From: Cherne, Curtis
Sent: Friday, August 09, 2013 8:46 AM
To: 'Jeffrey Mortensen'
Cc: Metro, Kristal D.
Subject: RE: BMX Park

**Re: COA Bike Park
Grading and Drainage Plan,
Engineer's Stamp dated 05-15-13 (L15/D013A)**

Re: BMX Park Improvements, 1903 Avenida Cesar Chavez SE, Traffic Circulation Layout
Architect's Stamp dated 07-23-13 (L15-D013A)

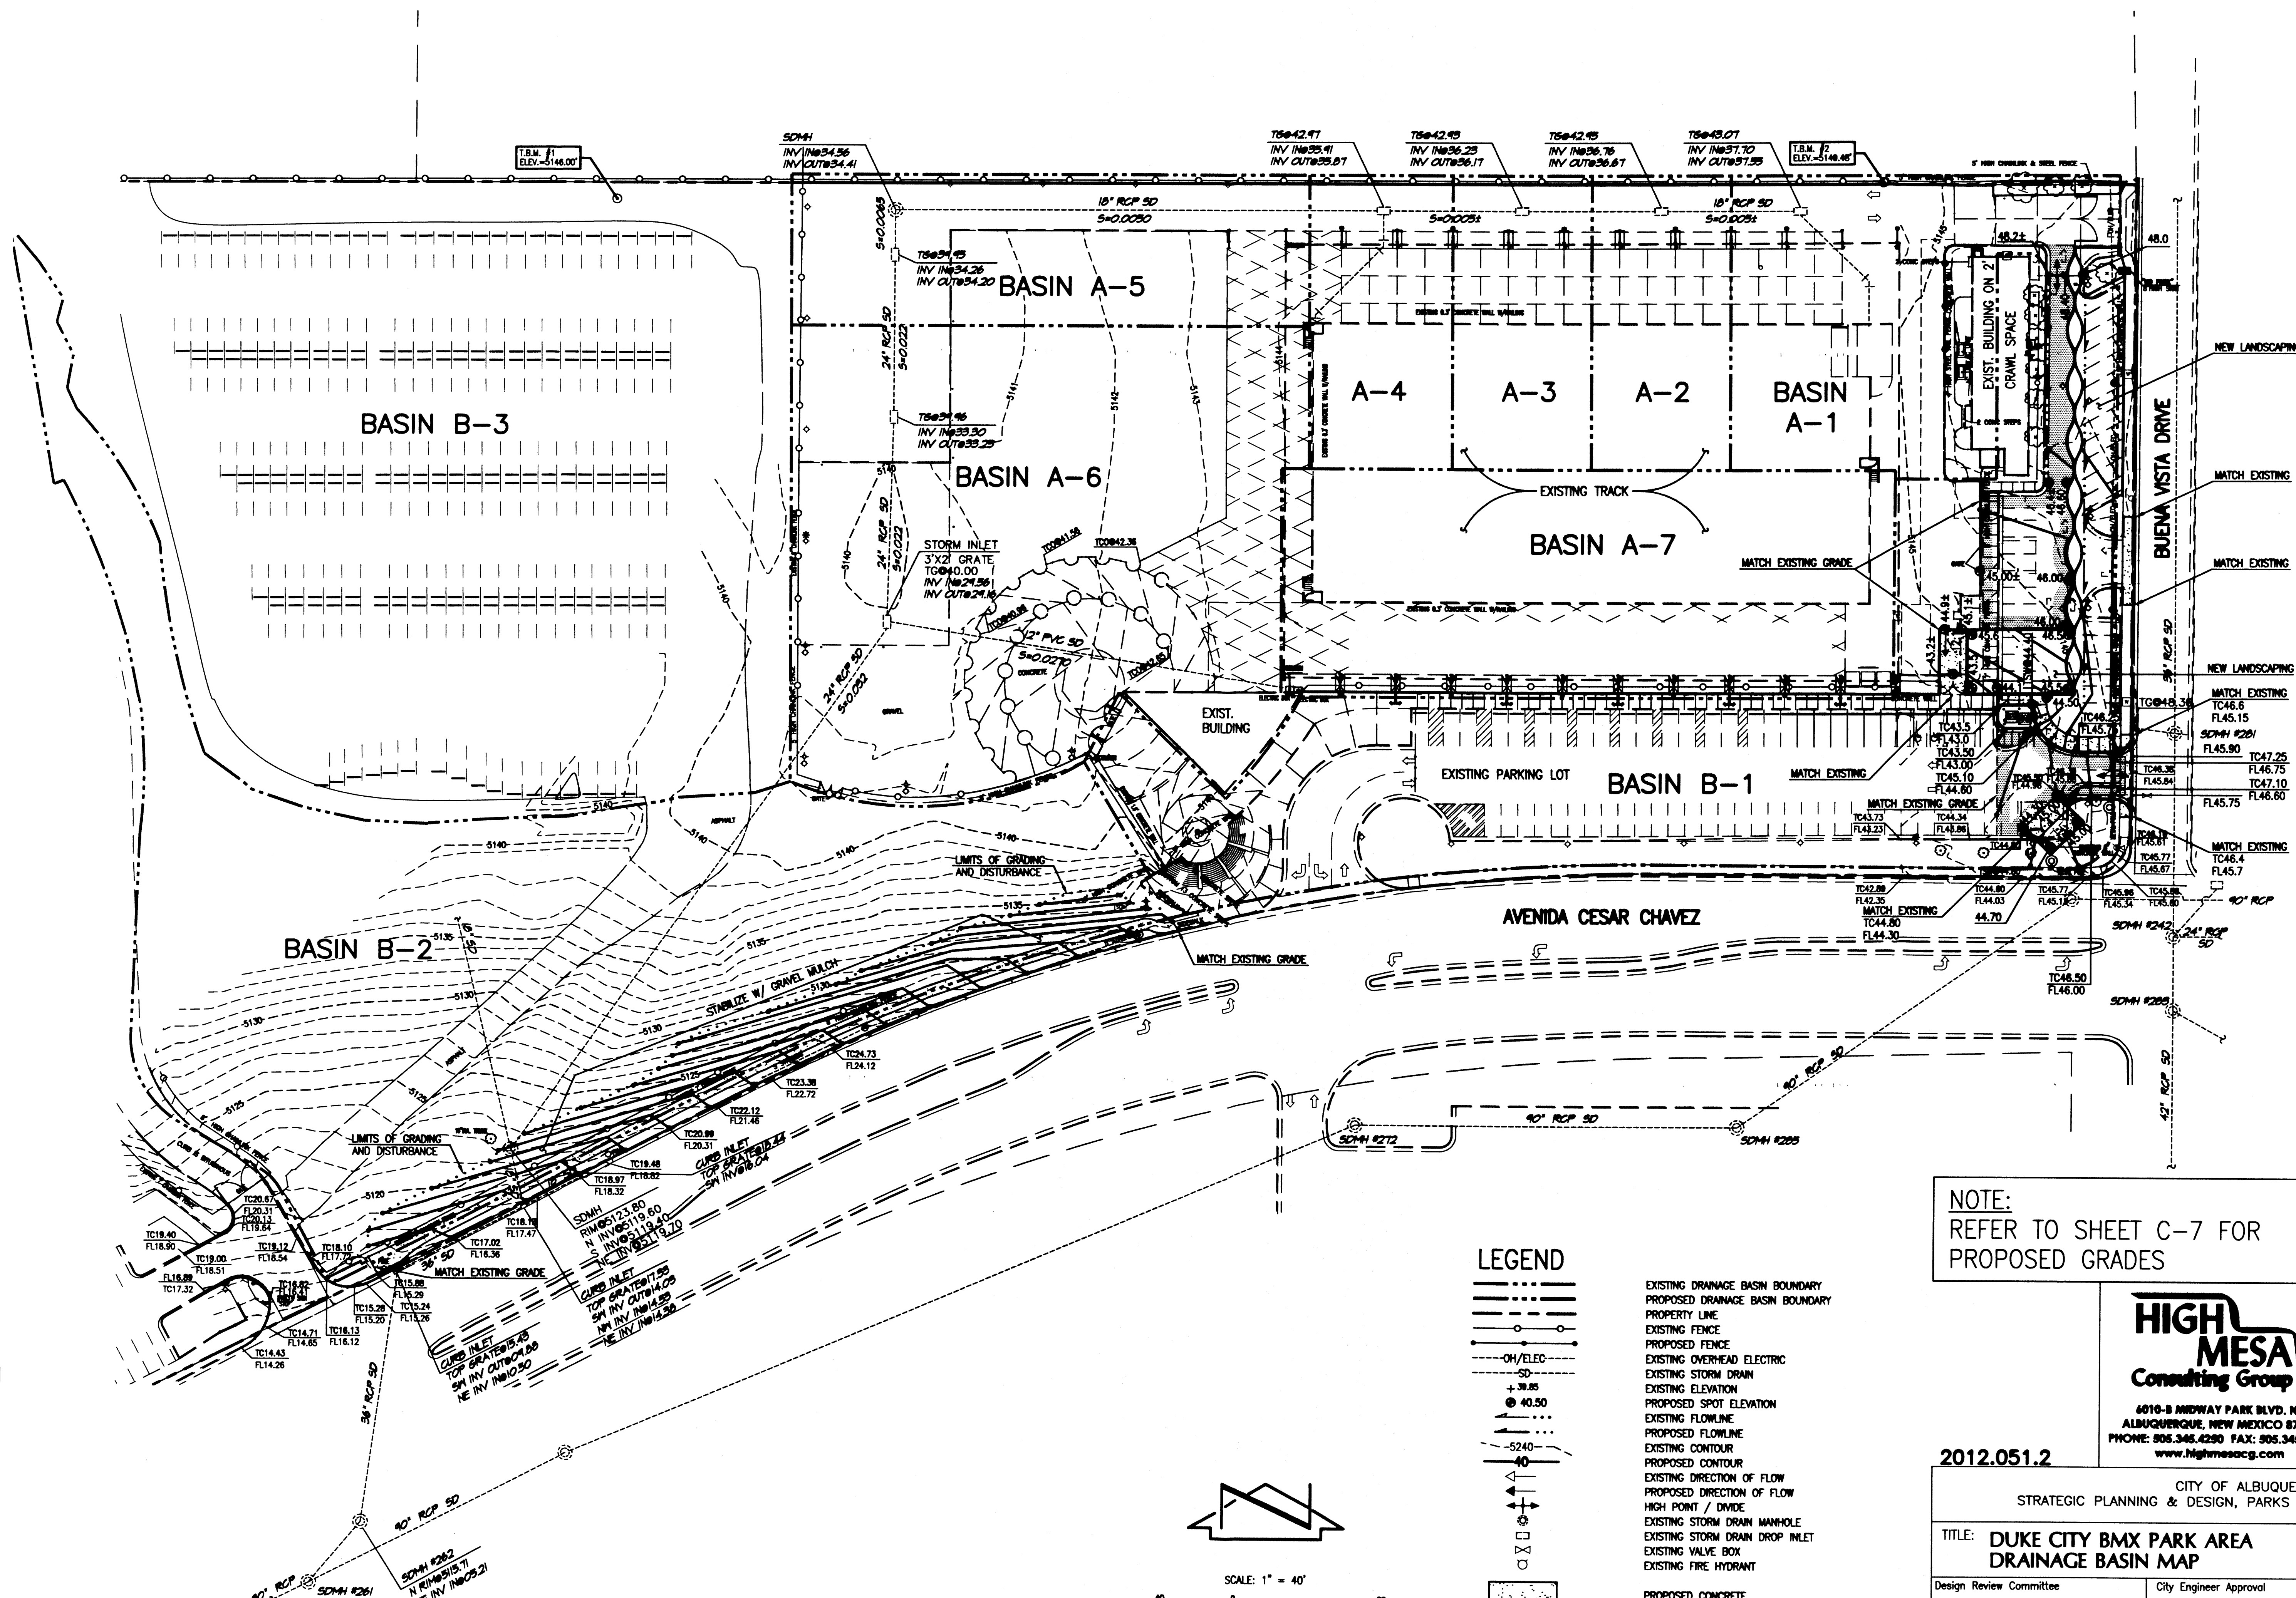
Jeff,
 I'm looking at your grading plan. It does not look like there is a conflict between the "c" inlet and the drive entrance. However, if there is, looks like if the entrance was shifted a little (3'?), there would not be a conflict.

This is an approved Plan. Increasing the radius of the entrance from Buena Vista conflicts with an existing C inlet.

I see it now. We HAVE TO have a 15' radius or we will not get the Transportation approval. If that means we need to remove and reconstruct the existing storm inlet in the west curblineline of Buena Vista to fit the 15' radius that is what we will have to do.

It appears that the NW curb return now conflicts with the existing storm inlet in the west curblineline of Buena Vista.

Do you want to try to match the south end of the inlet or remove and reconstruct it to fit the 15' radius?

I forget to mention that the radii on the new driveway at the east end of the parking lot were too small. They were only 10' instead of 15' for some reason.

I have attached an updated site base with this corrected for you to include in the addendum sketches.
